From: Michael Bingham [REDACTED]
Sent: 15 April 2020 15:41
To: Nicola Moore
Subject: Re: Request for further information FP/58/20/CLP
Attachments: 002_Block Plan.pdf; 82 Flansham Lane_Planning.pdf

TITLE  
Existing &  
Proposed

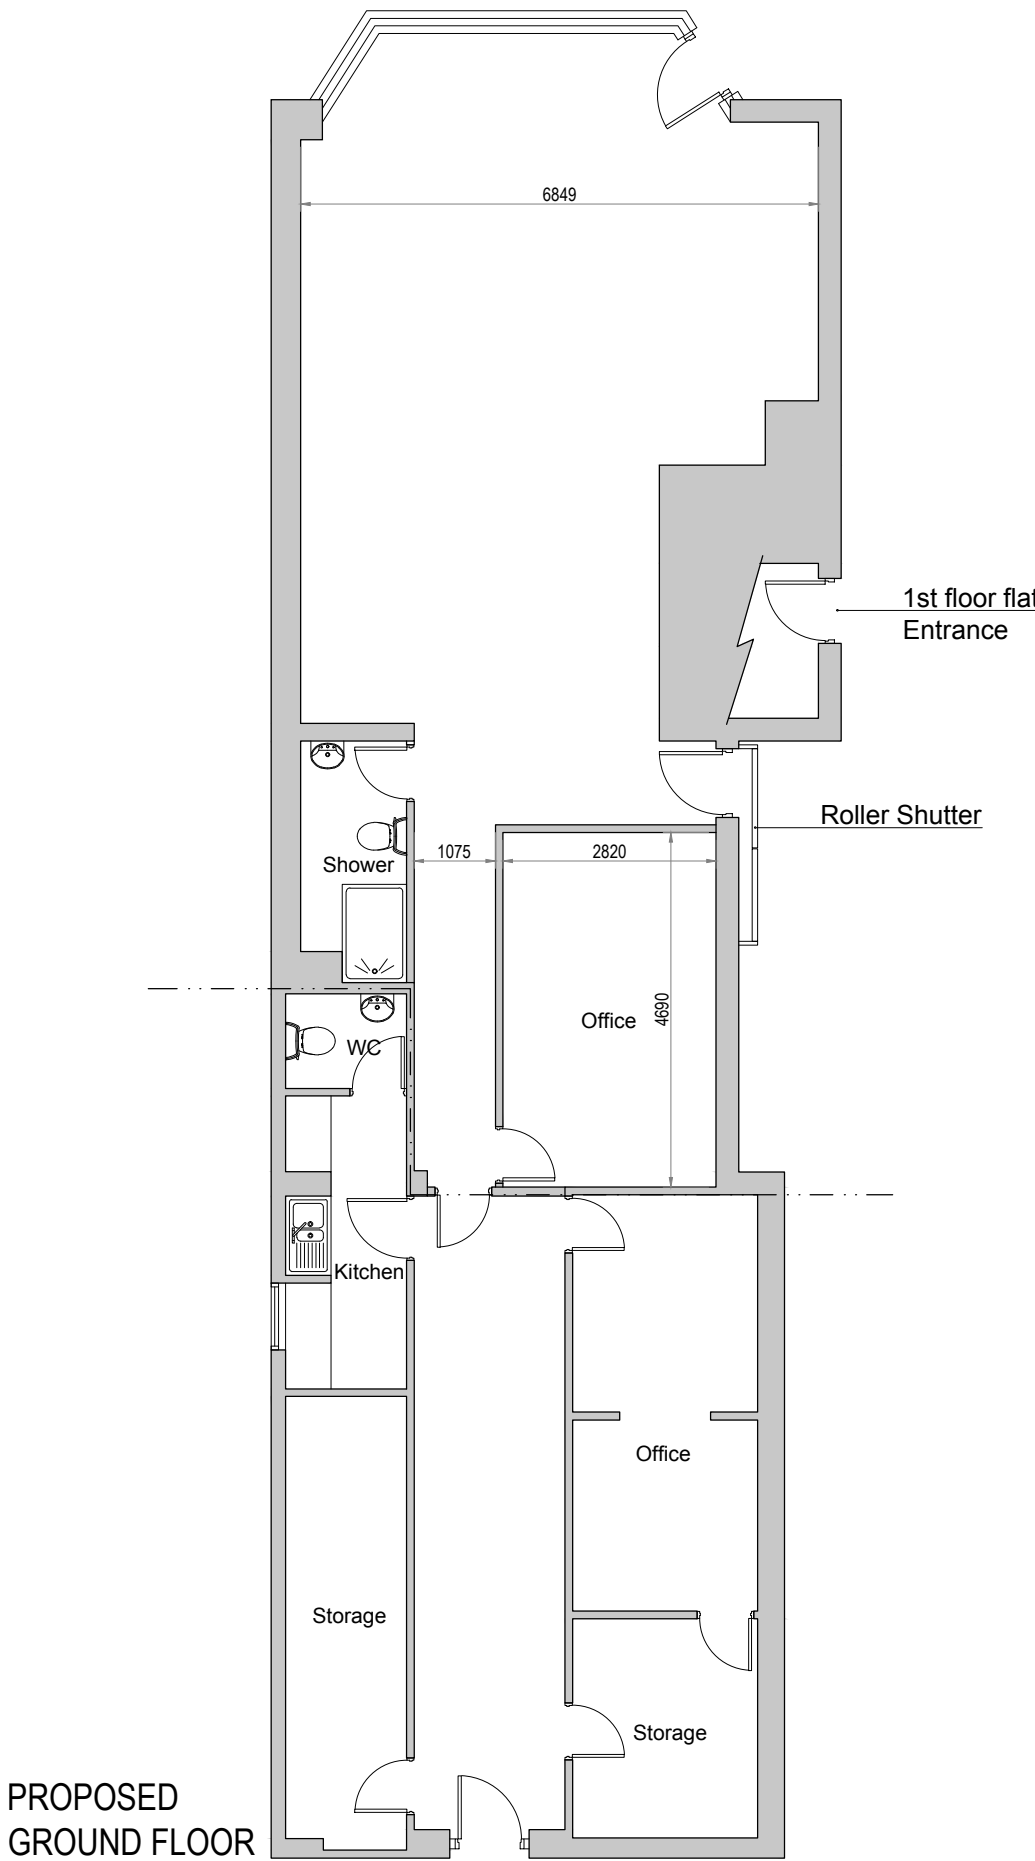
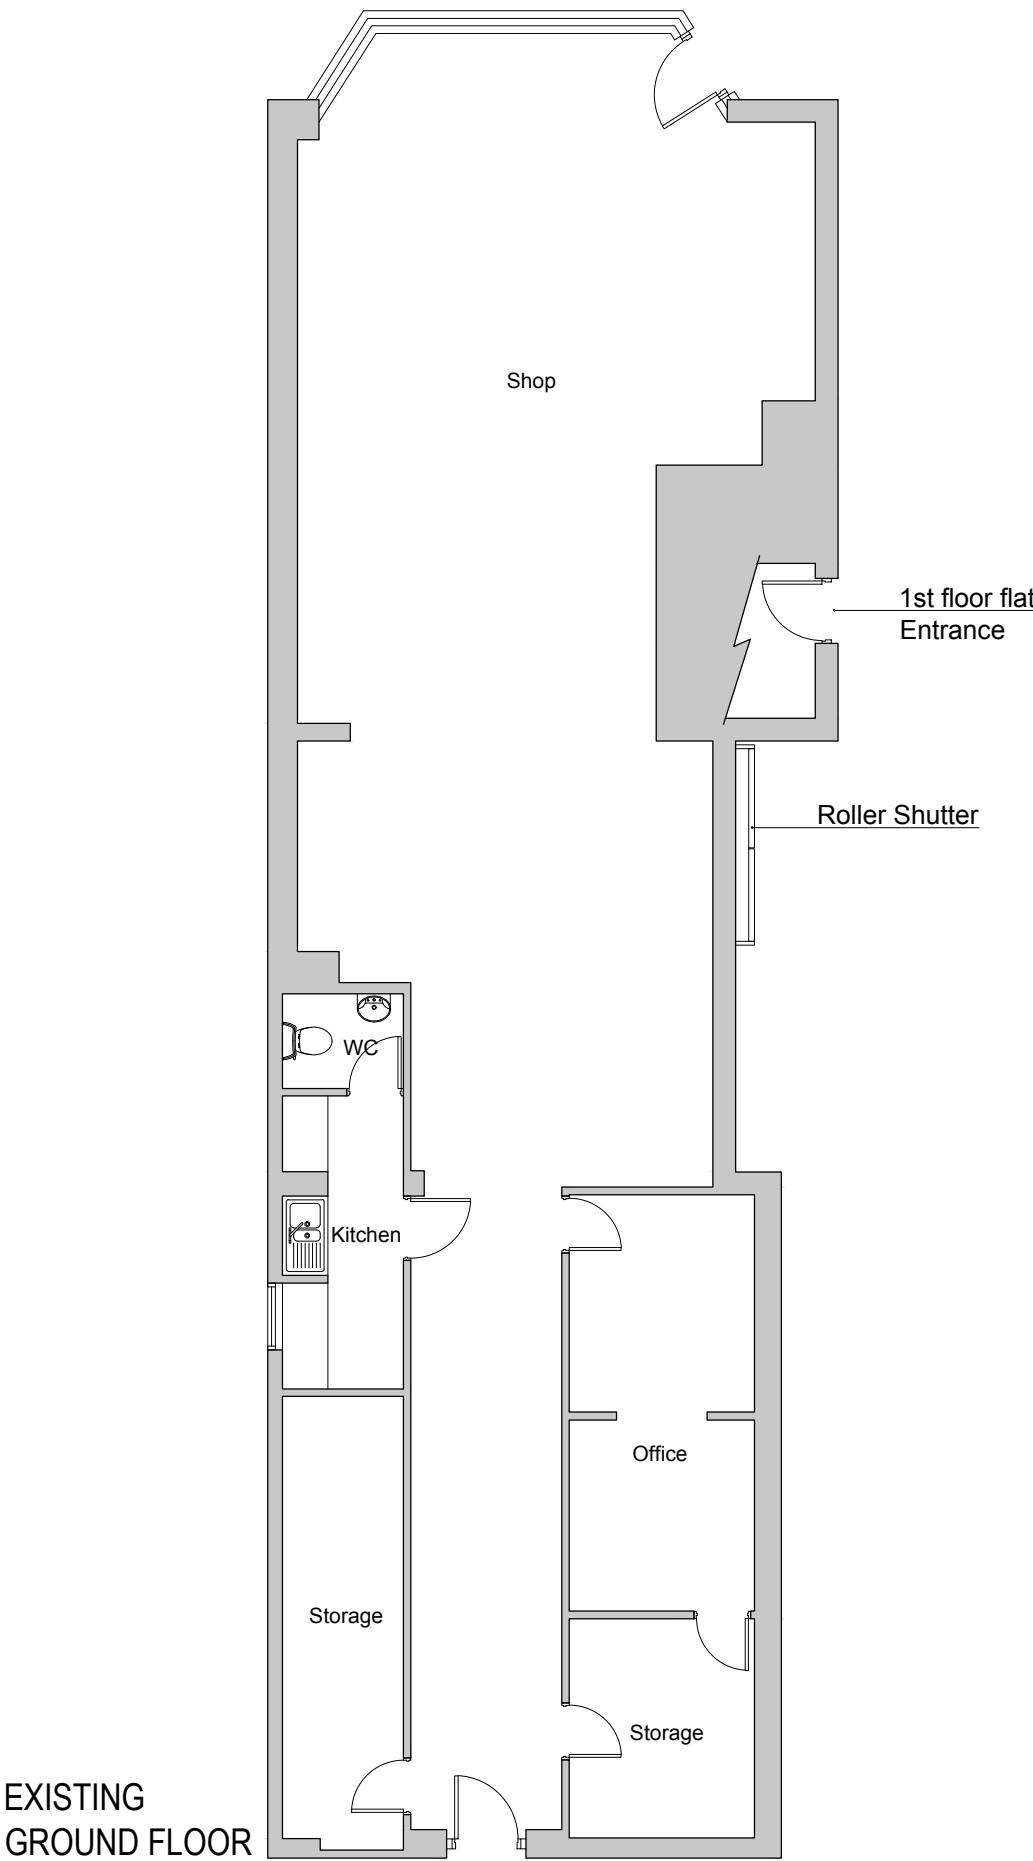
Having spoken with the architect, the floor plans were not correct. There is a roller shutter on the side elevation, and this is to remain, with the new door being located behind the shutter. Hopefully the amended attached floor plans will explain this (please supersede the original floorplan with the attached drawing), along with the attached photograph to show the existing side elevation.

TITLE
Existing & Proposed Elevations

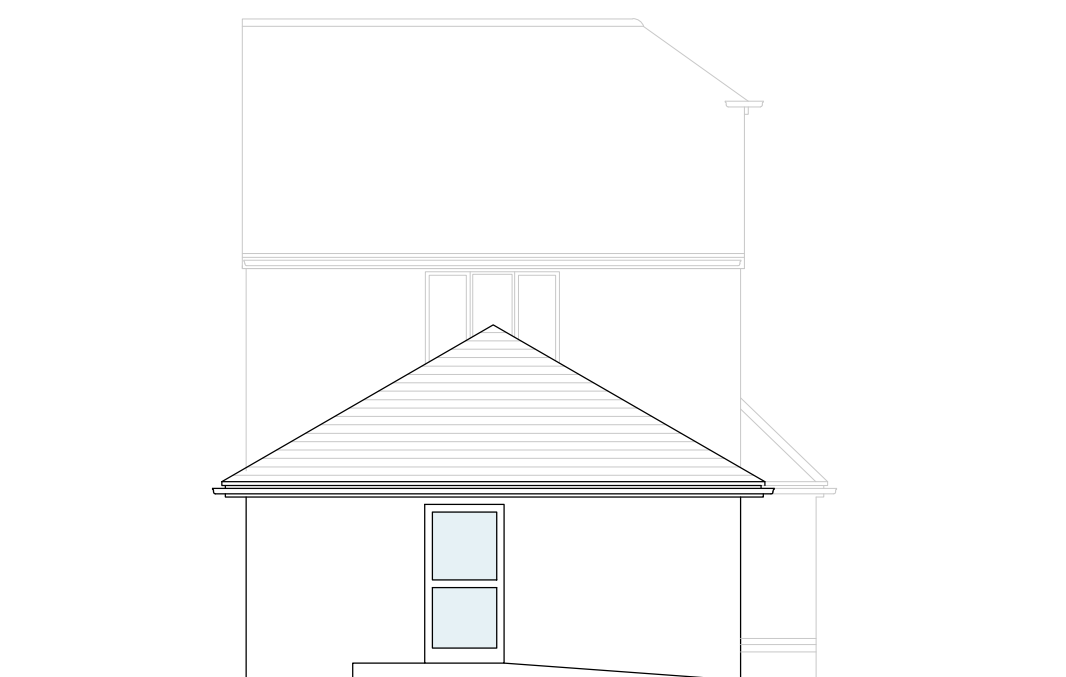
Although there are no external changes/alterations, an elevation plan is required, this can be one plan clearly labelled existing and proposed.

Please see attached block plan and elevations attached to the floor plan. Hopefully, everything is now in order to validate the application.
